**WELWYN HATFIELD BOROUGH COUNCIL
EXECUTIVE DIRECTOR - PLANNING, PUBLIC PROTECTION AND GOVERNANCE**

DELEGATED APPLICATION

Application No: 6/2021/0314/FULL
Location: 22 Church Lane Northaw Potters Bar EN6 4NX
Proposal: Erection of a 5 bedroom detached house
Officer: Ms Emily Stainer

Recommendation: Refused

Drawing No.
 2019/1327/3

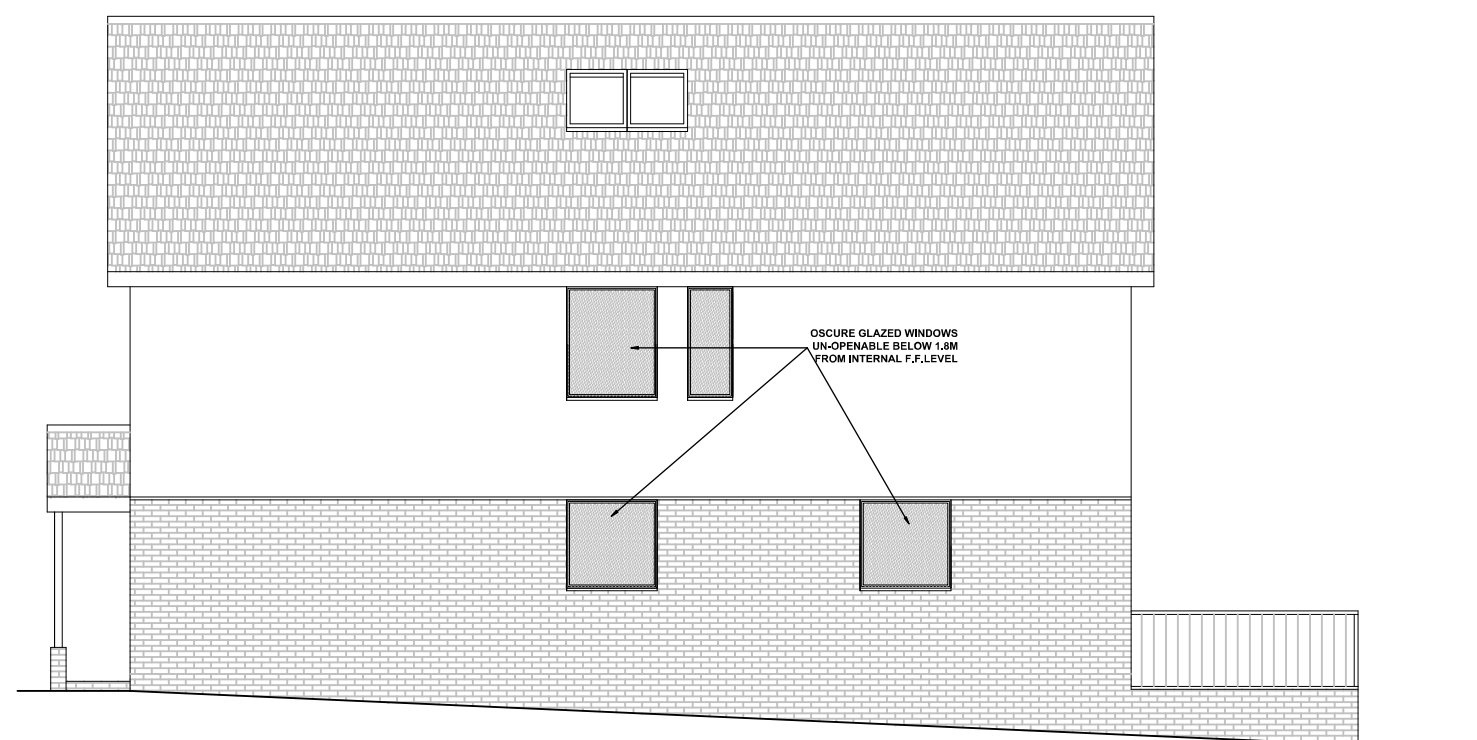
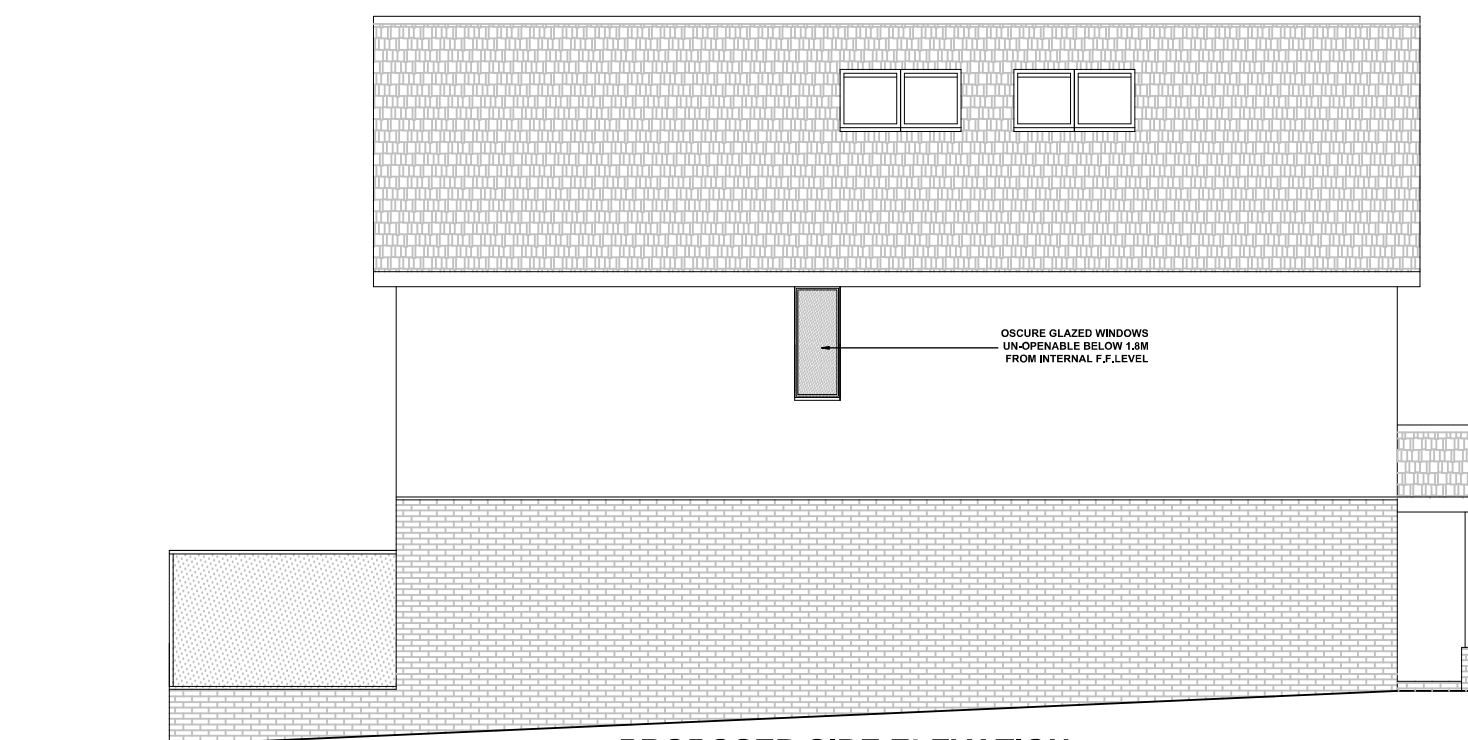
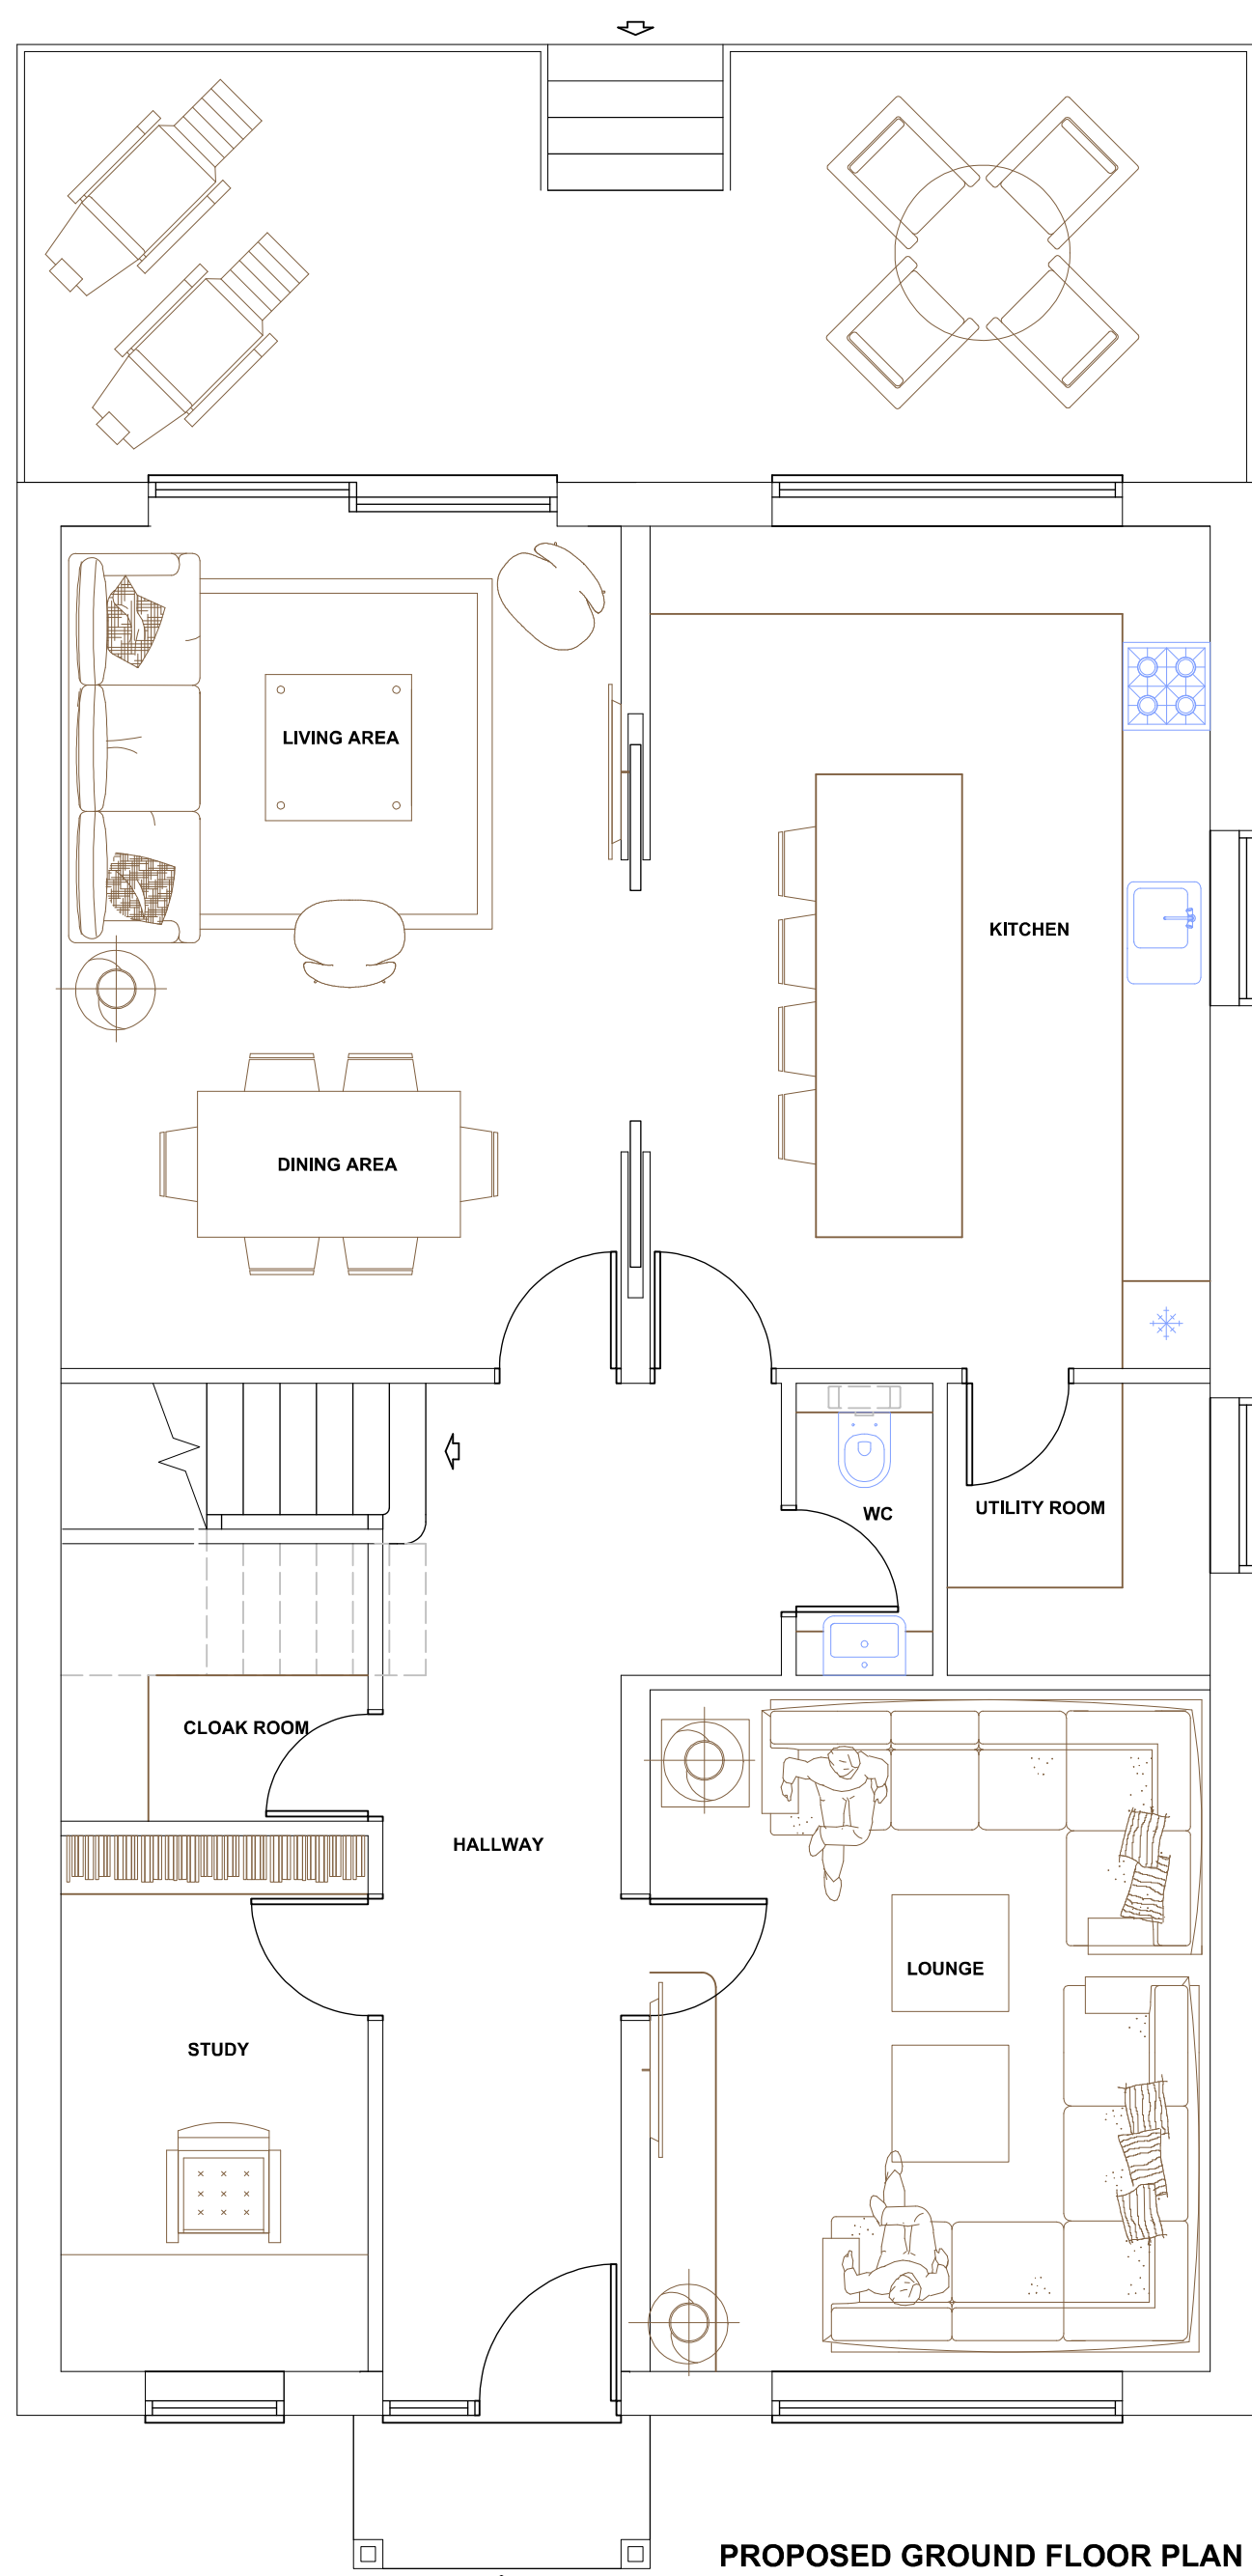
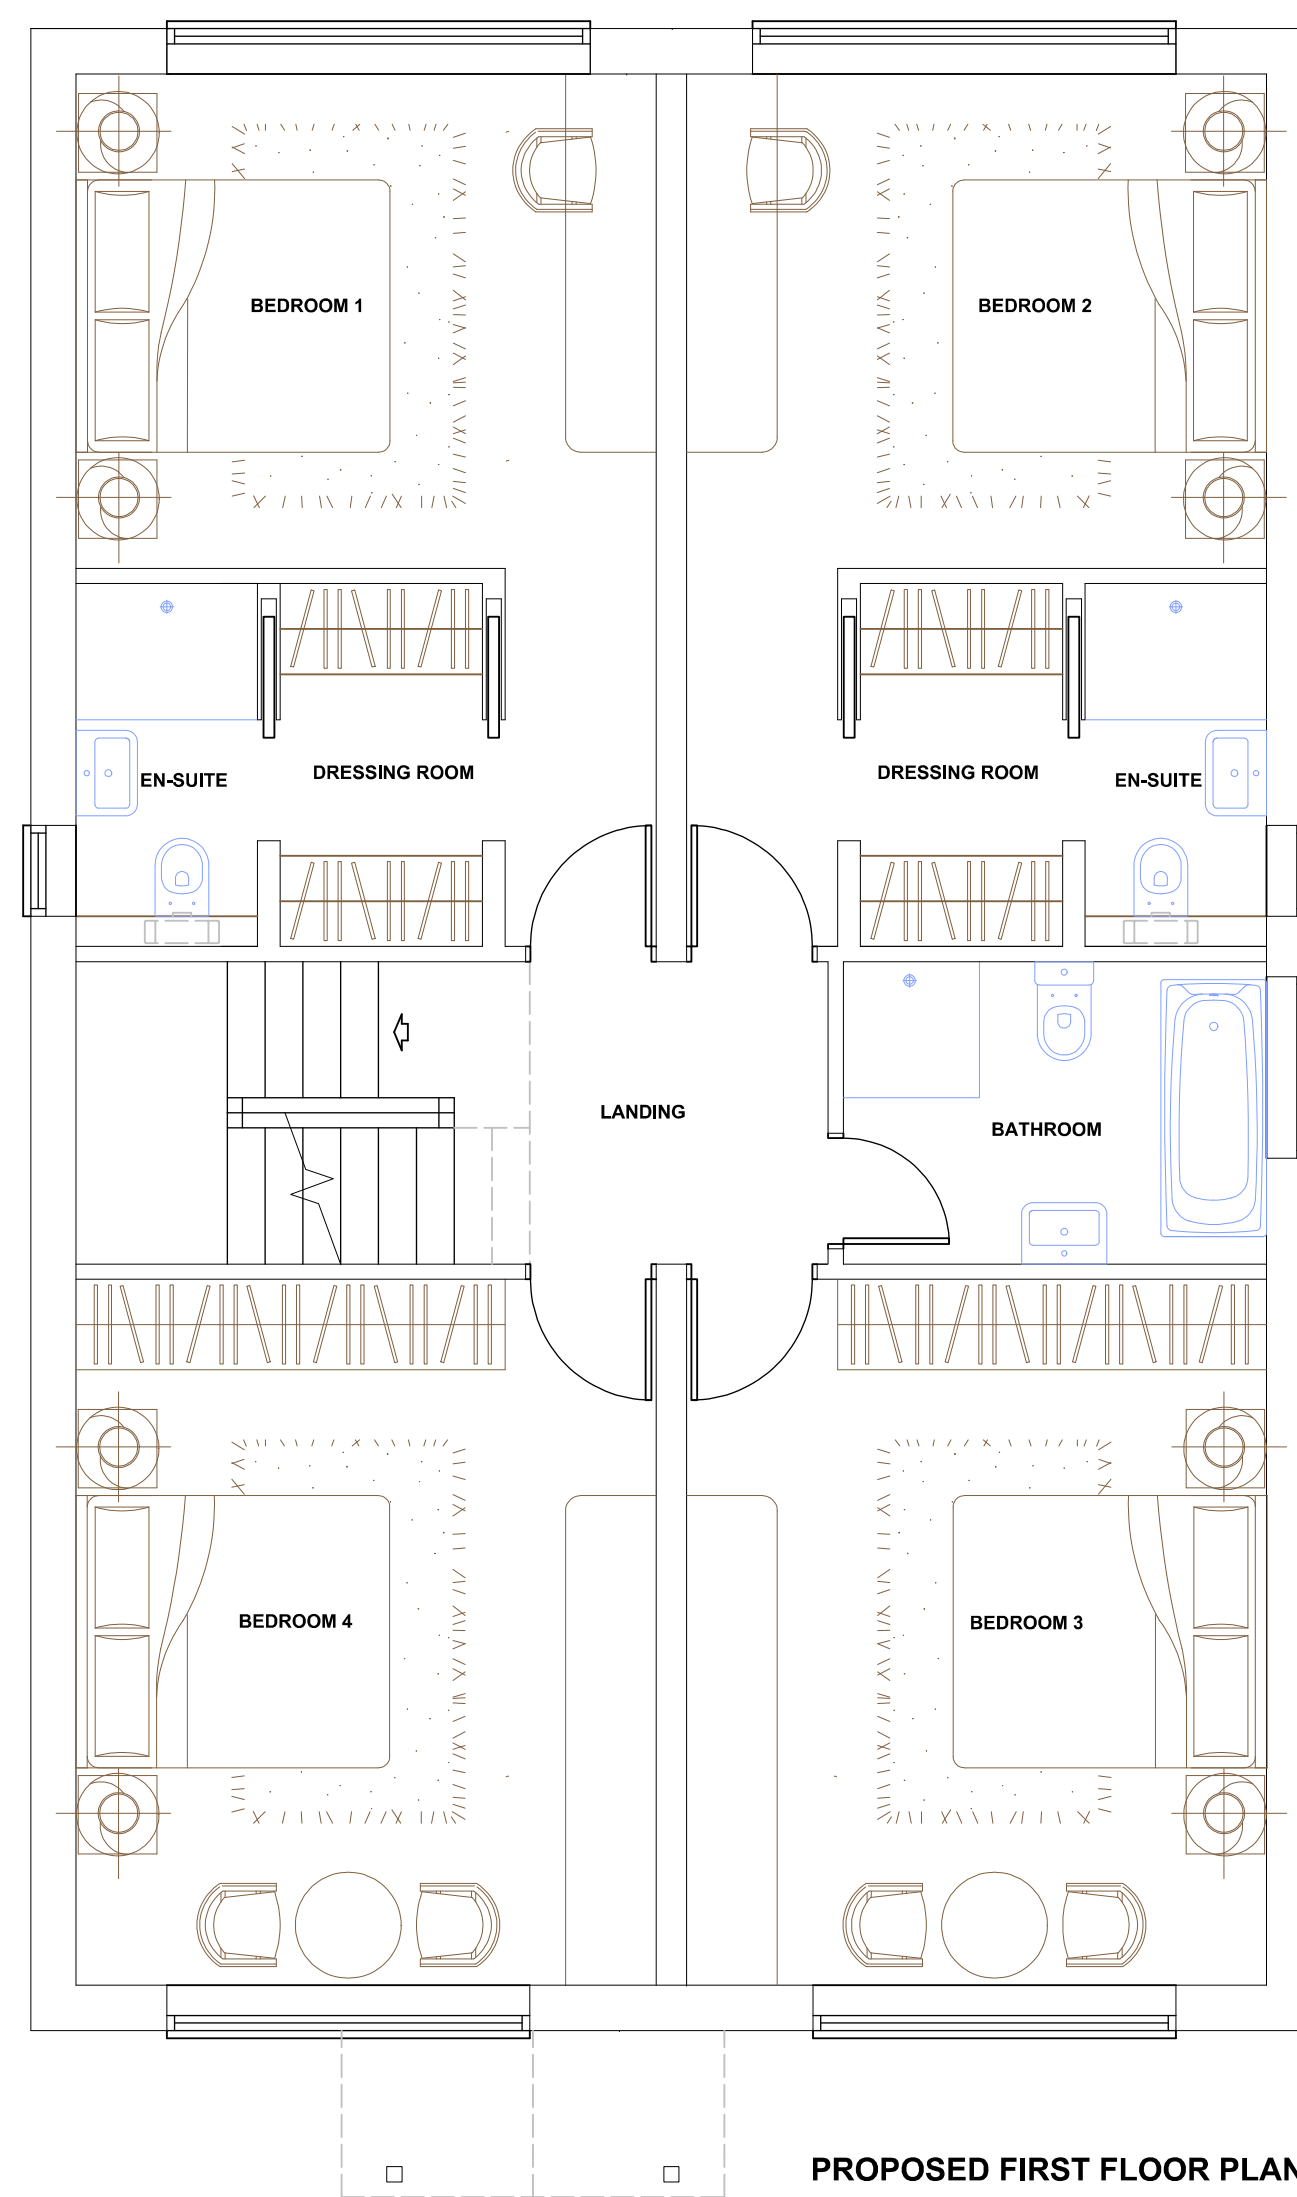
21 Church Lane is positioned to the west of the application property, on the opposite side of the road. It is oriented in a different manner to the properties on the east side as the rear garden backs onto the road and the dwelling is set much further back into the plot. For these reasons the proposed development would not be unduly over dominant or result in a loss of light to the habitable windows or garden of 21 Church Lane. The occupiers of this address have raised concerns about a loss of privacy. The proposed dwelling would have habitable windows at first floor and a front window serving the habitable accommodation in the roof space, from which views could be directed towards 21 Church Lane. Whilst it is acknowledged that the property would introduce overlooking in a location where there currently is none, this would not be dissimilar to views that can already be obtained from first floor windows at 22 Church Lane. Furthermore, the front porthole style window would serve a dressing room which is not a habitable room. In the event of permission being granted a condition could be imposed to ensure this window is obscure glazed to prevent overlooking of the garden at 21 Church Lane.

<p>An acceptable separation distance between the dwellings will be obtained to achieve an acceptable outlook and level of light to habitable rooms. Obscure glazed and fixed windows on the side elevations of the proposed dwelling will be secured by way of planning condition to prevent overlooking to neighbouring occupiers and future occupiers of the proposed scheme. This is acceptable as the windows are either serving non-habitable rooms or are secondary windows to habitable rooms.</p> <p>A neighbour comment has raised concerns about the level of amenity that would be afforded to the future occupiers of the proposed dwelling, partly due to inadequate internal room sizes. The Technical Housing Standards – Nationally Described Space Standards document (March 2015) suggests that a five-bedroom, two storey dwelling should have a minimum floor area of 128sqm and a five-bedroom, three storey dwelling should have a minimum floor area of 134sqm. The submitted plans indicate that all bedrooms would benefit from double beds. Subsequently, as the submitted plans indicate that the proposed dwelling would be approximately 250sqm in size internally, the proposal would be in compliance with the minimum floor space standards for a five bedroom dwelling. The proposal would therefore provide satisfactory accommodation for its future occupiers.</p> <p><u>Conclusion</u></p> <p>Subject to the suggested conditions, it is therefore considered that the living conditions of the adjoining occupiers will be maintained to an acceptable level and would result in an acceptable level of amenity for future occupiers of the development, in accordance Policy D1 Welwyn Hatfield District Plan 2005 and Supplementary Design Guidance 2005.</p>
